CITY OF ALBUQUERQUE

August 15, 2019

Re: Project Name
3301 Candelaria Road NE
Traffic Circulation Layout
Engineer's/Architect's Stamp 08-21-2019 (G16D097)

1 Site Plan - Proposed
Scale: 1" = 20'-0"

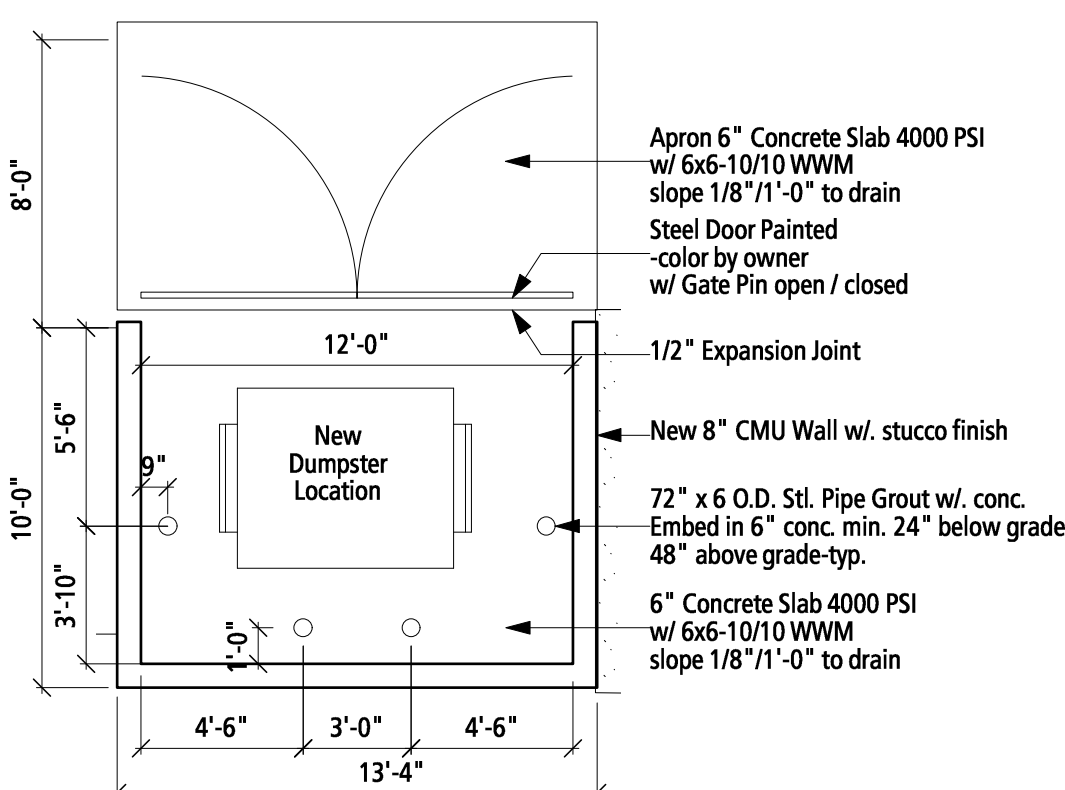
1. Part of the new drivepad portion is outside the property line. Refer to the picture.
2. Per DPM, a 6 ft. wide ADA accessible pedestrian pathway is required from the ADA parking stall access aisles to the building entrances. Please clearly show this pathway and provide details.
3. The drive-pad exists. Why are you calling it a new drive pad.
4. Please remove all the bubbles.
5. The clear site triangles needs to be shown at the site access area. Refer to attached document.
